**The Arcade, Dewsbury
& 18-20 Corporation Street / 17 Foundry Street**

Design and Heritage Statement Addendum

1705-BDP-AD-XX-RG-Z-00006

1 Third Floor Removals Plan
1 : 100

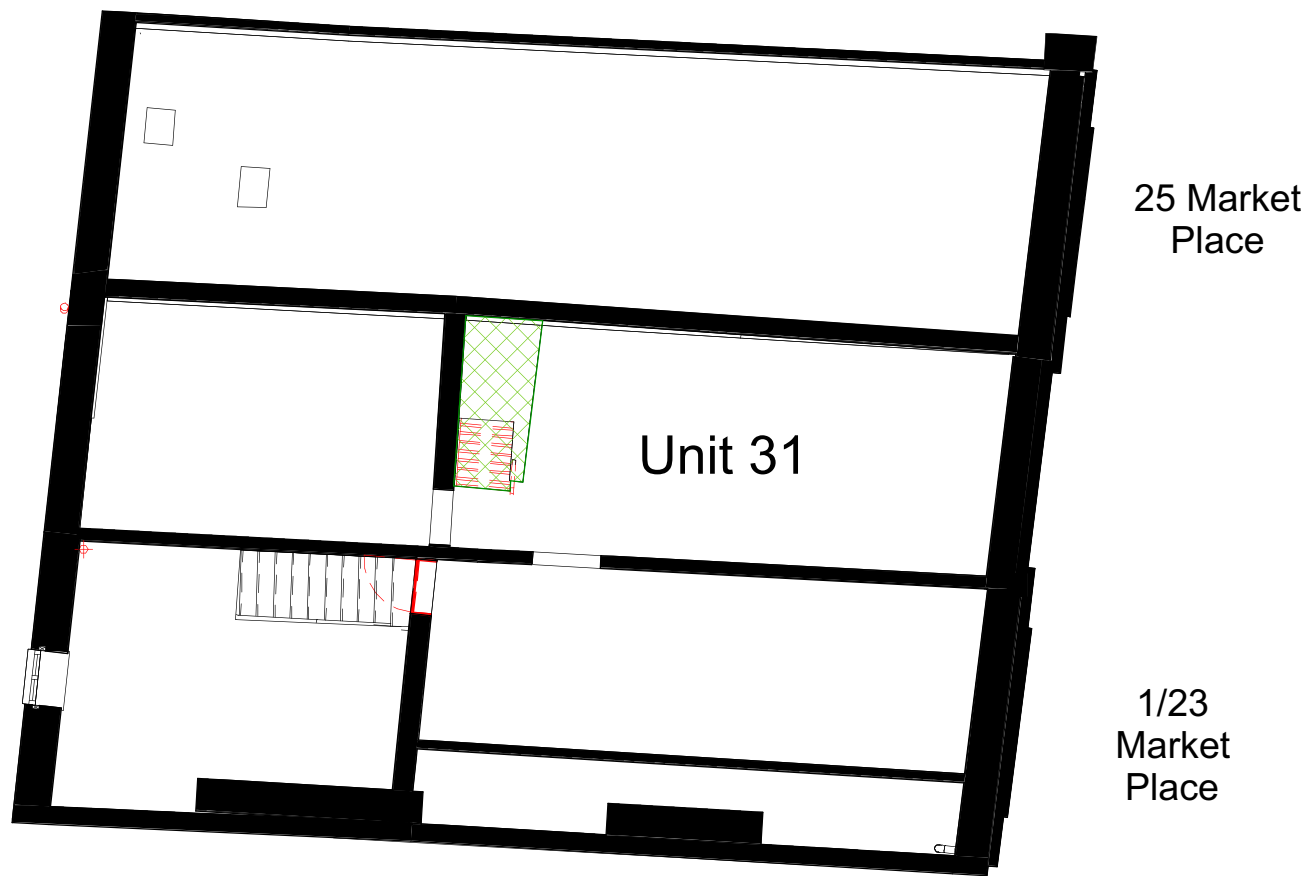
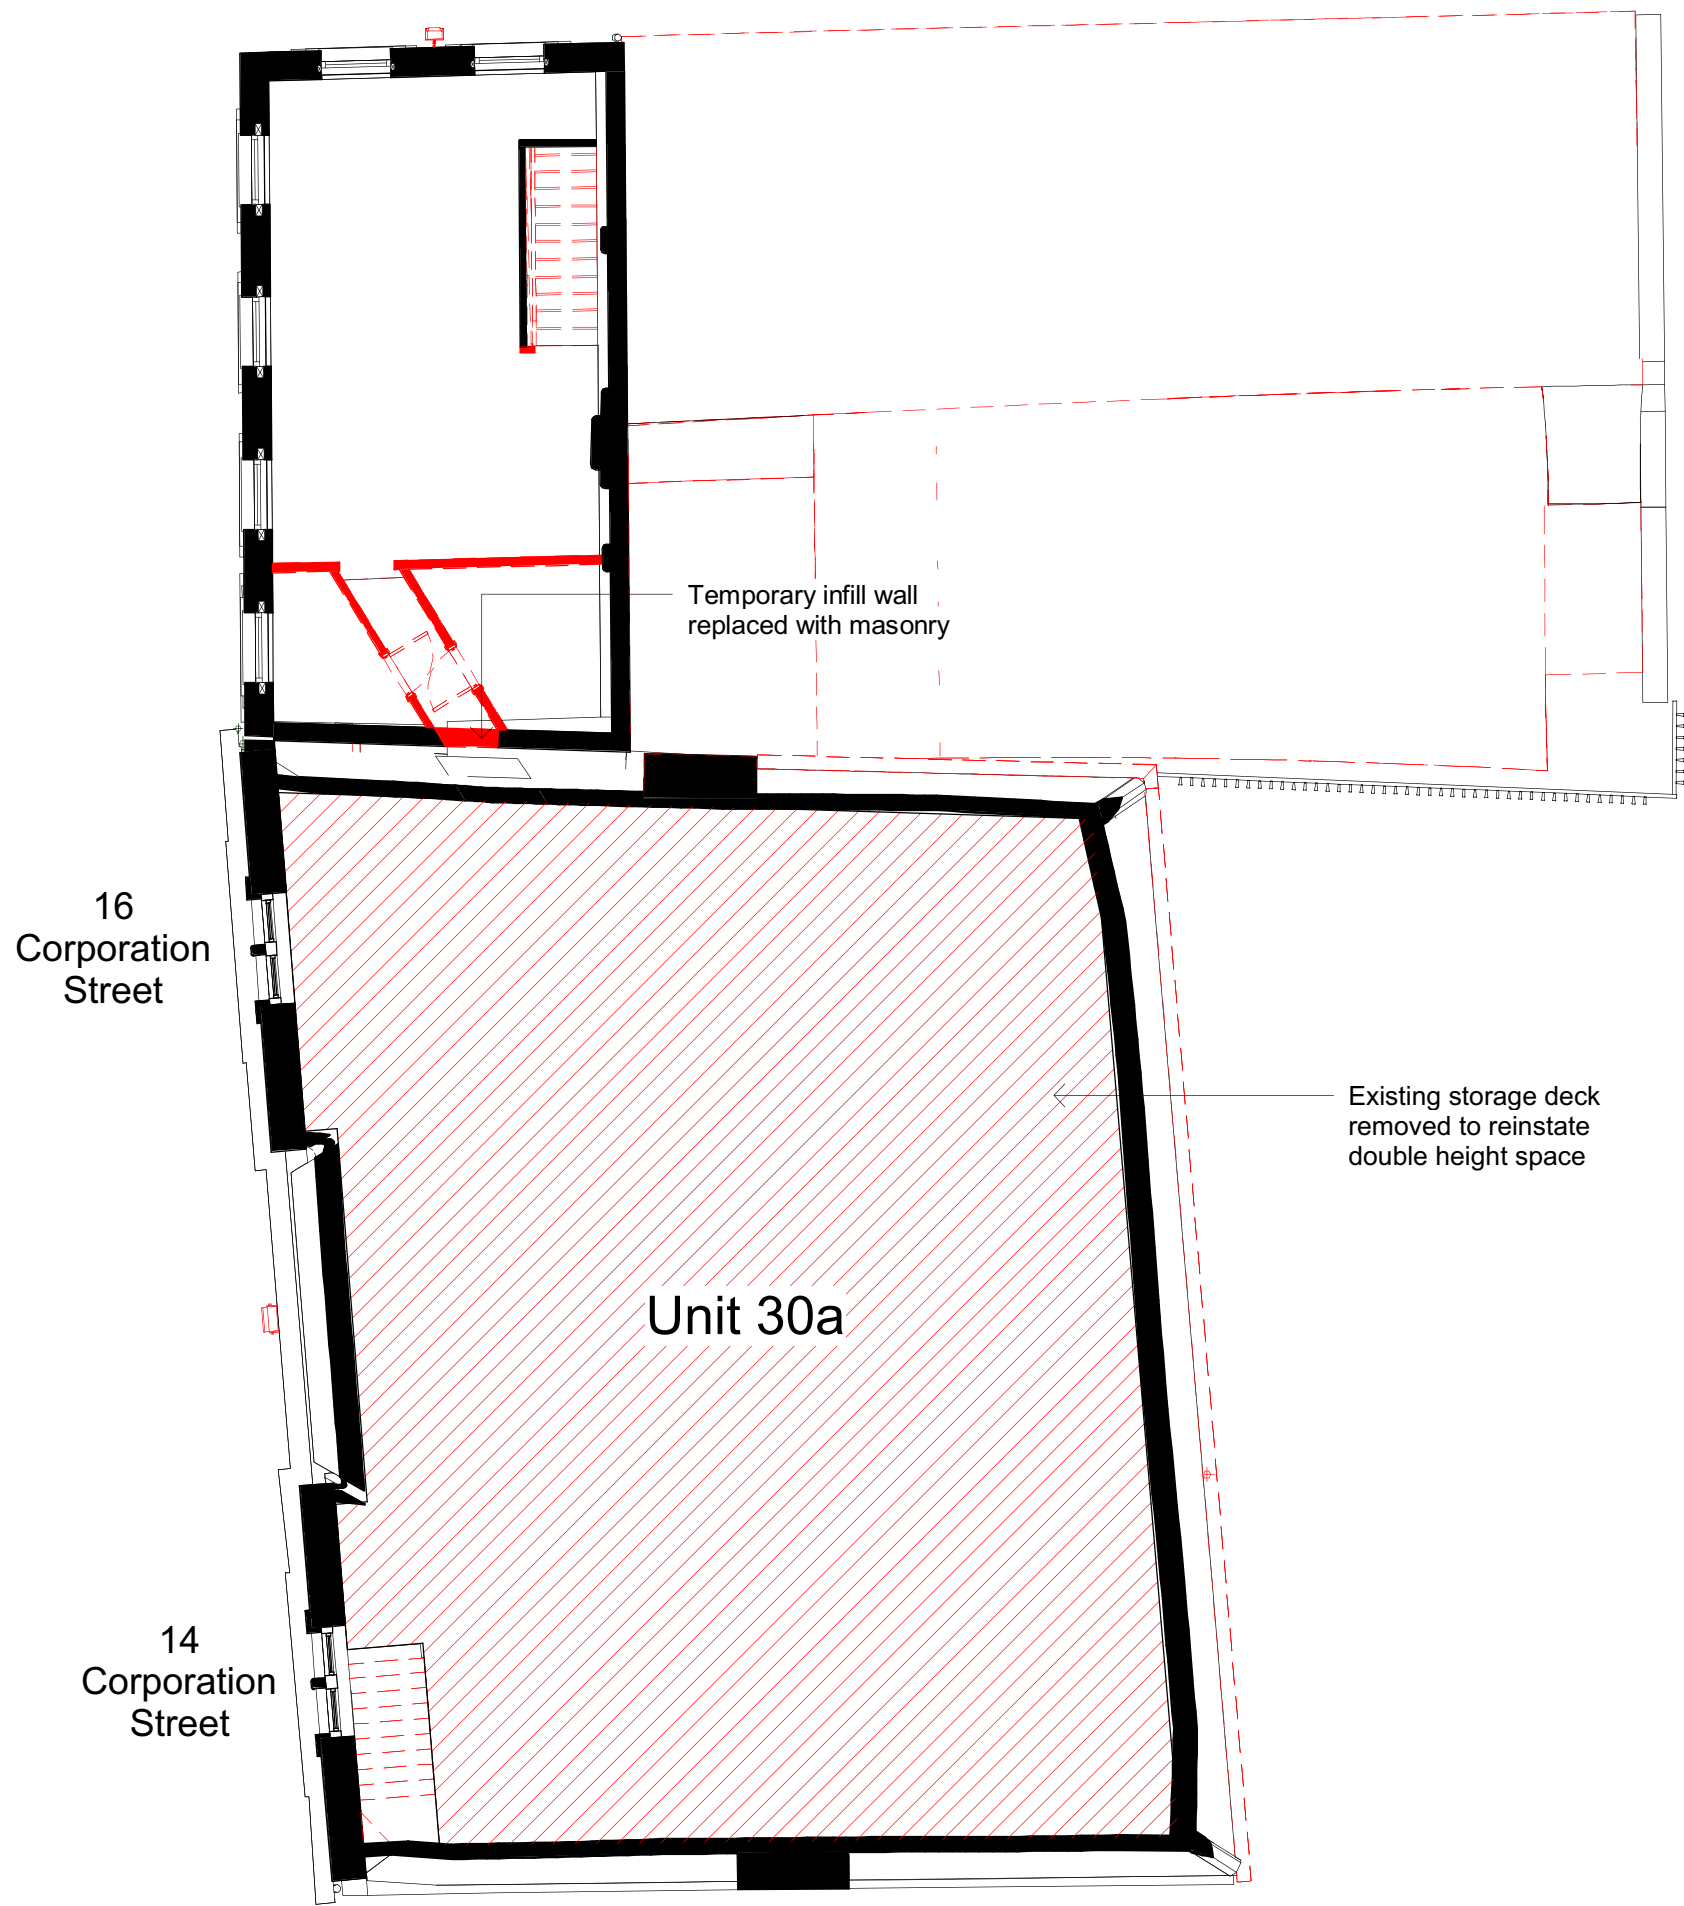
Ref	Location	Element	Original consented proposals	On-site discoveries (where applicable)	Issue caused / Opportunity for improvement	Proposed solution to address issue	Impact (see 1.2)	Relevant drawing(s) as consent	Updated proposed drawings
009	14-16 Corporation Street Unit 30 / Unit 30a	Storage deck	Repair the existing timber joisted storage deck above unit 30 (forming a storage area known as unit 30a). Remove the permanent stair, and provide an access hatch and sliding ladder.	Accessing this storage area (which was previously unsafe to access) has revealed that the pattern painted onto the bottom chords of the trusses visible in unit 30 continues onto the rest of these queenpost trusses (the principal rafters and struts). The original construction drawings in the West Yorkshire Archives indicate an open roof space. Additionally, the extent of wet and dry rot would necessitate a higher quantum of timber repairs.	CONDITION + ENHANCEMENT: Opportunity to reinstate part of the building to its earlier arrangement, improving the spatial quality of this room which was originally constructed as a workshop for the stores below.	Remove this storage deck that required extensive timber repairs and reinstate the space to its original historic arrangement. Omit the ladder and access hatch previously proposed.	Moderate Beneficial	1705-BDP-AD-02-PL-A-20001_T01 1705-BDP-AD-03-PL-A-20001_T01 1705-BDP-AD-03-PL-A-20002_T01	1705-BDP-AD-02-PL-A-20001_T02 1705-BDP-AD-03-PL-A-20001_T02 1705-BDP-AD-03-PL-A-20002_T02

1 First Floor Removals Plan

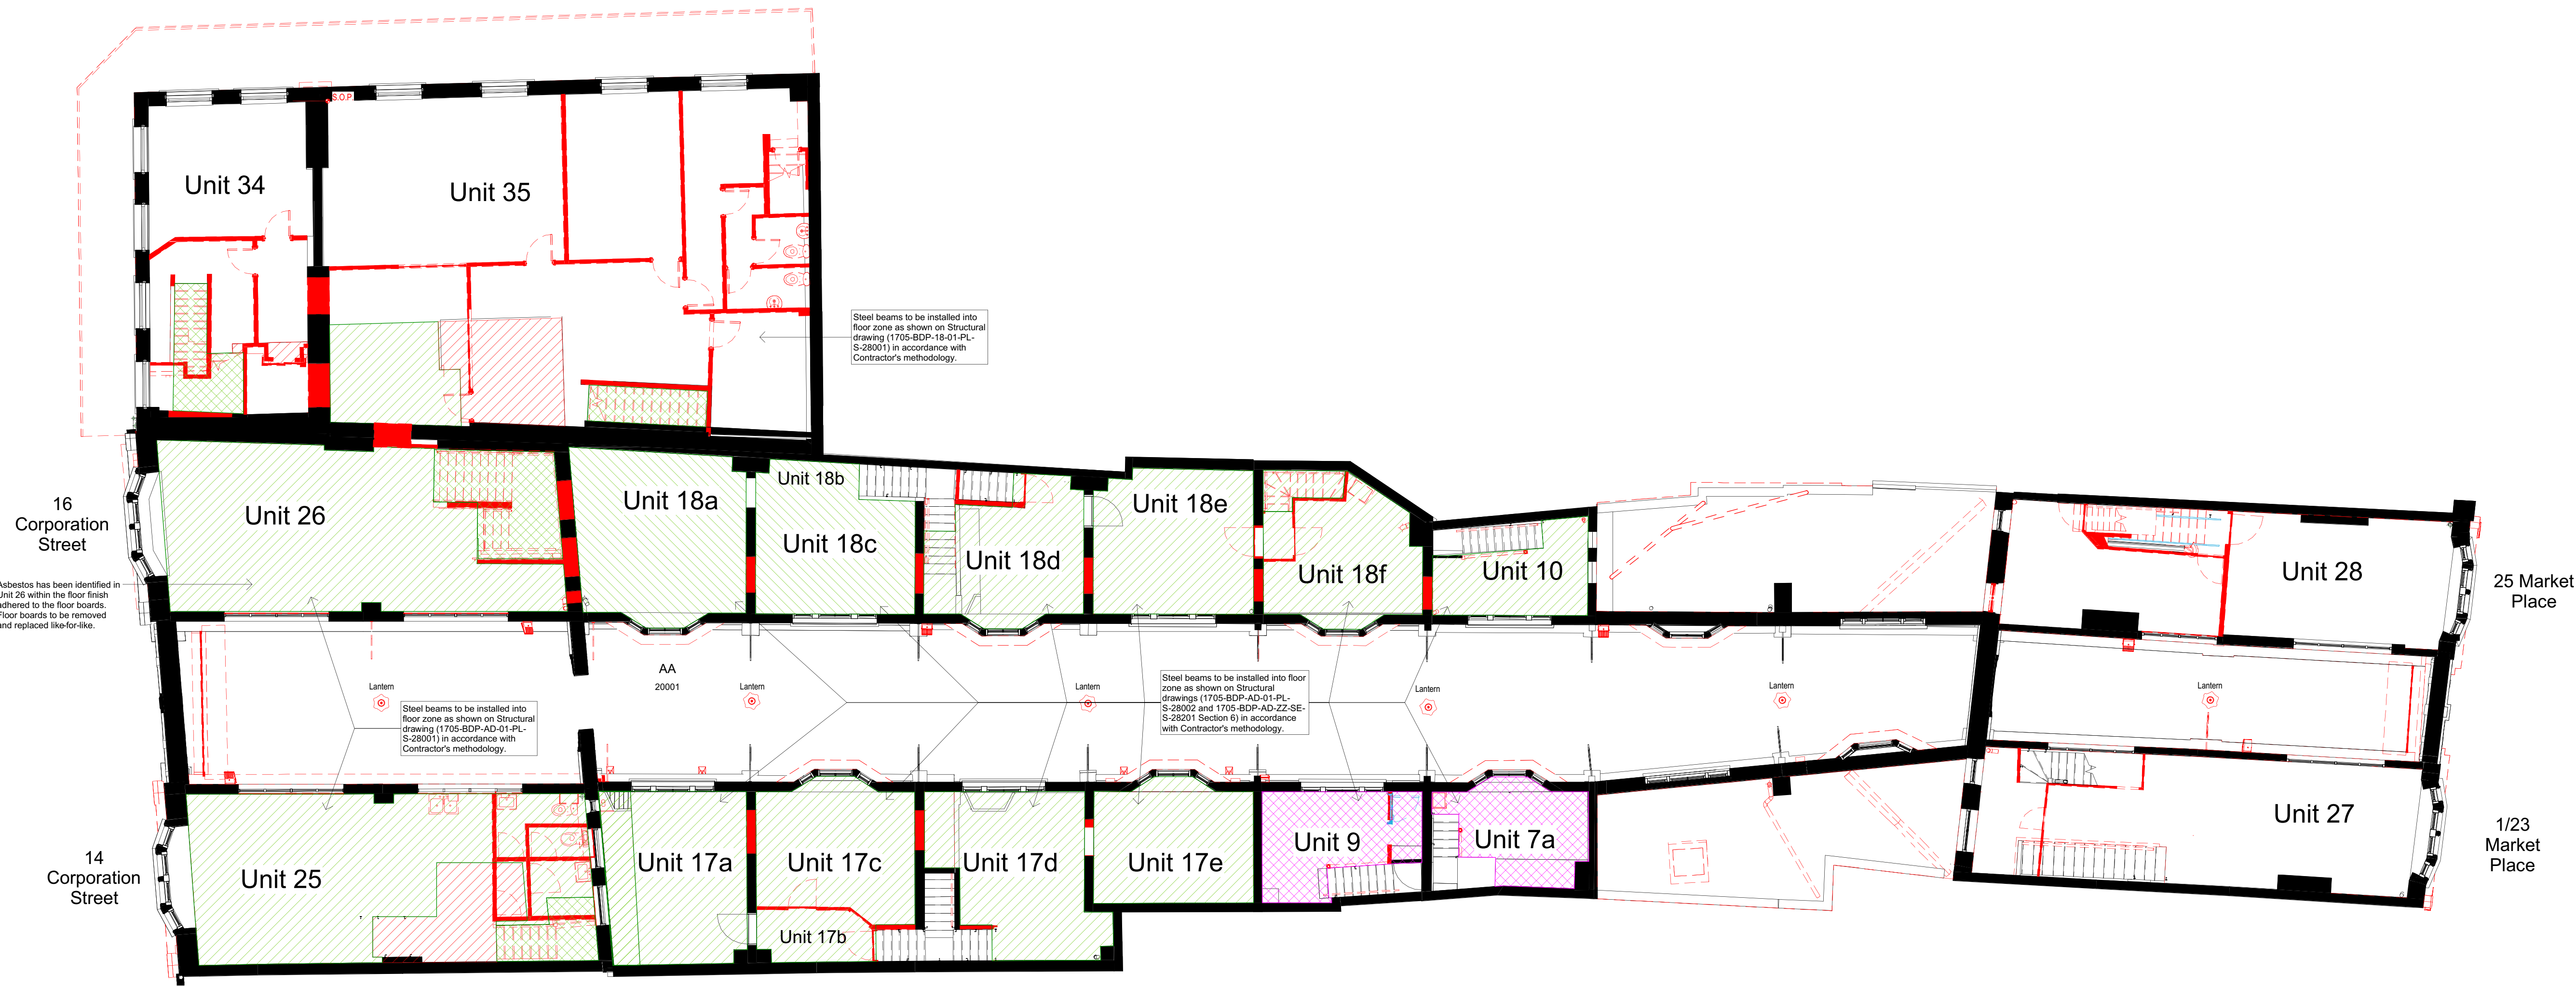
005	Central Arcade Units 9 and 17b	Internal partitions	Existing partitions were assumed to be historic lath and plaster partitions to be retained and upgraded to meet the new fire performance requirements for a 60-minute protected stairway where applicable.	Following on-site opening up, the partitions were found to be a mix of more modern construction and were generally poorly built incorporating hard board / MDF.	LIFE SAFETY + PERFORMANCE: These were not historic elements of the building with heritage value as evidenced by their absence on the historic plans in the West Yorkshire Archives, and it would not be practical to upgrade them to provide 60 minute fire resistance to support continued viable and flexible uses.	Replace these sections of partition with new plasterboard partitions to provide the required fire resistance. This is the same approach that had already had consent for the partitions forming the fire-protected stair in unit 18b on the opposite side of the arcade.	Negligible	1705-BDP-AD-01-PL-A-20001_T01 1705-BDP-AD-01-PL-A-20002_T01	1705-BDP-AD-01-PL-A-20001_T02 1705-BDP-AD-01-PL-A-20002_T02

006	18-20 Corporation Street and 17 Foundry Street Unit 34 / 35	Stairwell and door	No lobby to top of stair. New door to swing outwards.	n/a	LIFE SAFETY: For safe fire evacuation, it has been proposed that these units should be lobbied from the protected stair, and the door to unit 34 should swing into unit 34, to avoid impacting the escape route from unit 35 and support continued viable and flexible uses.	Minor change to internal layout with new lobby added. Door to swing inwards (into unit 34)	Negligible	1705-BDP-AD-01-PL-A-20001_T01 1705-BDP-18-ZZ-PL-A-00002_P06	1705-BDP-AD-01-PL-A-20001_T02 1705-BDP-18-ZZ-PL-A-00002_P07
007	Central Arcade First floor units	Floors	Units 17d, 18a, 18b, 18c and 18d: replace the floors due to wet and dry rot. Units 7a, 9, 10, 17a-c, 17e, 18d-f, 25, 26 and 35: Refurbish the floors: lift boards, strengthen and repair existing joist structure. Reinstall existing boards wherever practical and supplement with new.	Additional timber surveys have revealed extensive wet and dry rot had already been identified in units 17d, 18a, 18b, 18c and 18d, 25, 26 and 35. Further wet and dry rot was found in the remaining units affecting the joists and floorboards.	LIFE SAFETY + CONDITION: The existing joists were damaged by wet and dry rot to the extent that their condition was very bad and strengthening them was not practicable to support continued use. The floorboards were similarly damaged and in poor condition so that only short lengths could be recovered for reuse.	Replace the timber joist floor structure to the remaining units in the areas that have been affected by wet and dry rot (as had already been had consent for units 17d, 18a, 18b, 18c and 18d). Recover all lengths of floorboard which are suitable for reuse and install them in units 7a and 9, with new floorboards to matching profiles used elsewhere. This will allow two units to retain and evidence the appearance of their original floor.	Minor Adverse	1705-BDP-AD-01-PL-A-20002_T01	1705-BDP-AD-01-PL-A-20002_T02
